DECISION DELEGATED TO HEAD OF PLANNING

Application No: H13-0691-24 **Applicant:** John & Maureen Biggadike Foundation

Proposal: Details of boundary treatments, parking areas, proposed hours of opening & closing & securing access gates/arrangements during periods of closure, location of bat & bird boxes (Conditions 3, 4, 6 & 8 of H13-1066-23)

Location: Moulton Park Bell Lane Moulton

**Site layout plan
Discharge of planning conditions 3, 4 and 8**

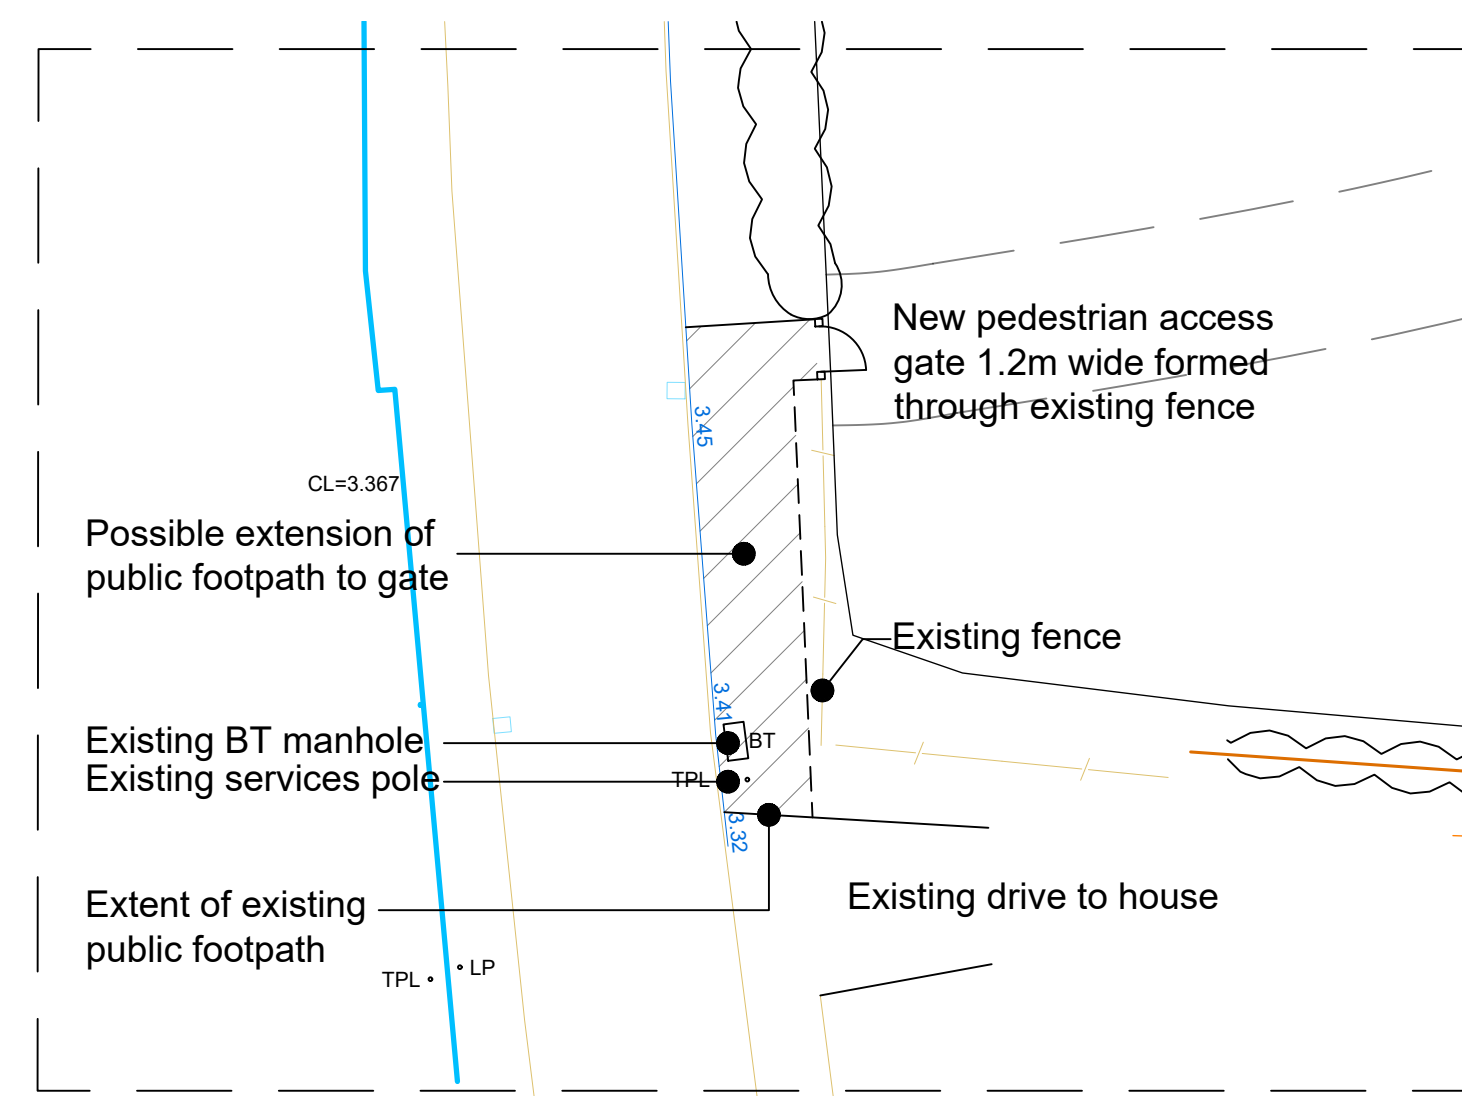
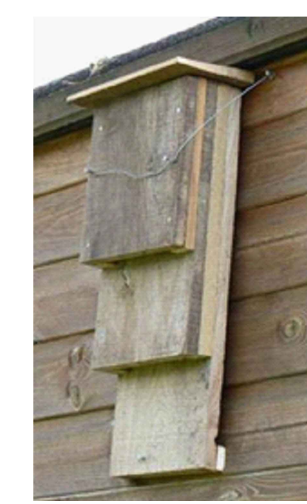
The submitted information, in the form of a covering letter and two drawings, comprising a site layout plan (A1732-10 Rev: CD1) and a car park layout plan (A1732-11 Rev: CD1), details that all existing hedgerow is to be retained and maintained. This is consistent with the conditions attached to the permission, and ensures that the hedging, which runs along the majority of the site boundaries, is to be retained in its current form.

The submitted details also detail the installation of 'Wooden two-rail fencing' to be sited around the permitted car park.

The extent of these boundary treatments largely reflects those typically expected in such a development and overall, these boundary treatments are considered to be acceptable.

The submitted layout plan shows the location of bat and bird boxes to be installed within the site. It is viewed that, should it be deemed appropriate at a later date, a number of bird and bat boxes could easily be installed in the surrounding trees.

It is considered that details in this regard are acceptable and can be discharged.

Car park layout

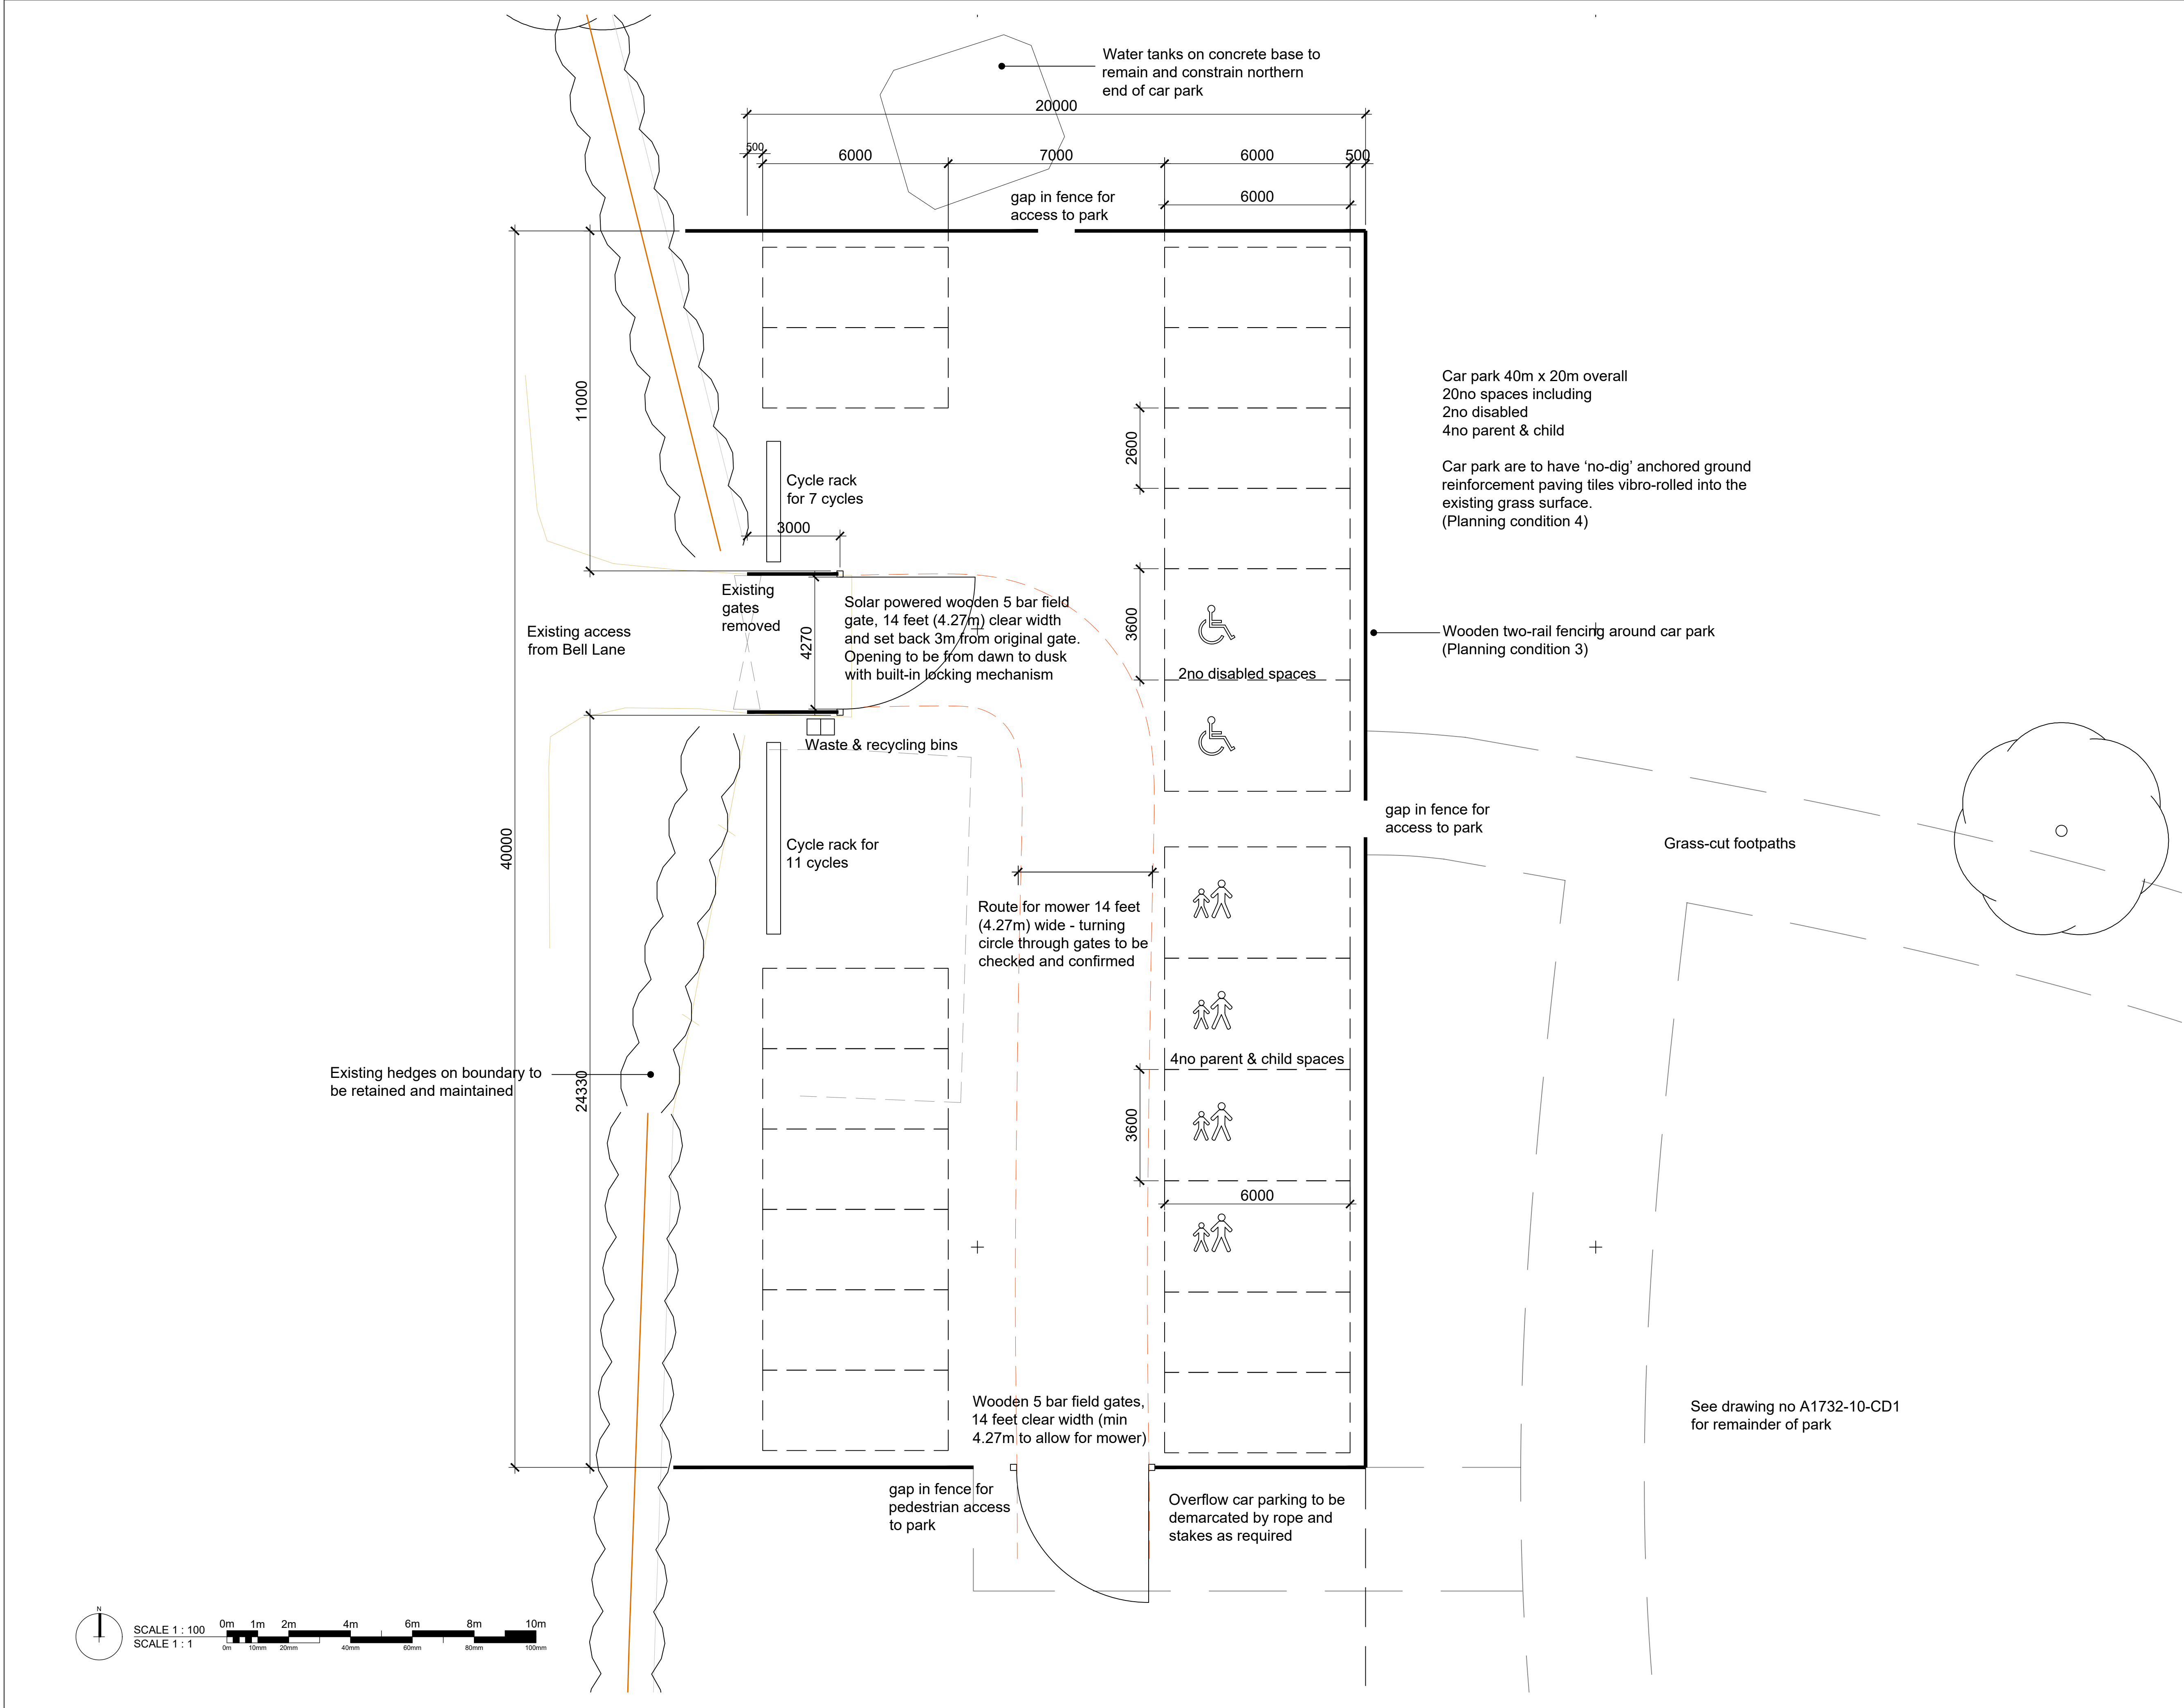
The submission comprises a detailed layout of the car park, including 20 spaces (inclusive of 2x disabled and 4x parent & child spaces). Two cycle racks of a wooden design, are also to be located within the area, enclosed by the aforementioned wooden style rail fencing.

The surface of the car park shall be a 'no-dig' anchored ground reinforcement paving tiles vibro-rolled, placed into the existing grass surface. The area shall be accessed via a solar powered 5 bar wooden gate (4.27m in width) and a 5 bar wooden pedestrian access gate (1.2m width). The gates shall be accessed 'dawn until dusk'.

These details are appropriate for the setting and are considered to be suitable for the character of

the area, whilst ensuring adequate function. These details are therefore considered acceptable.

The means of enclosure and hours of opening have been provided within the submission, in addition to this, the details illustrate that the area of car park shall be accessed via a solar powered 5 bar wooden gate (4.27m in width) and a 5 bar wooden pedestrian access gate (1.2m width). The gates shall be accessed 'dawn until dusk'.

The details provided are considered suitable. These details are therefore considered acceptable.
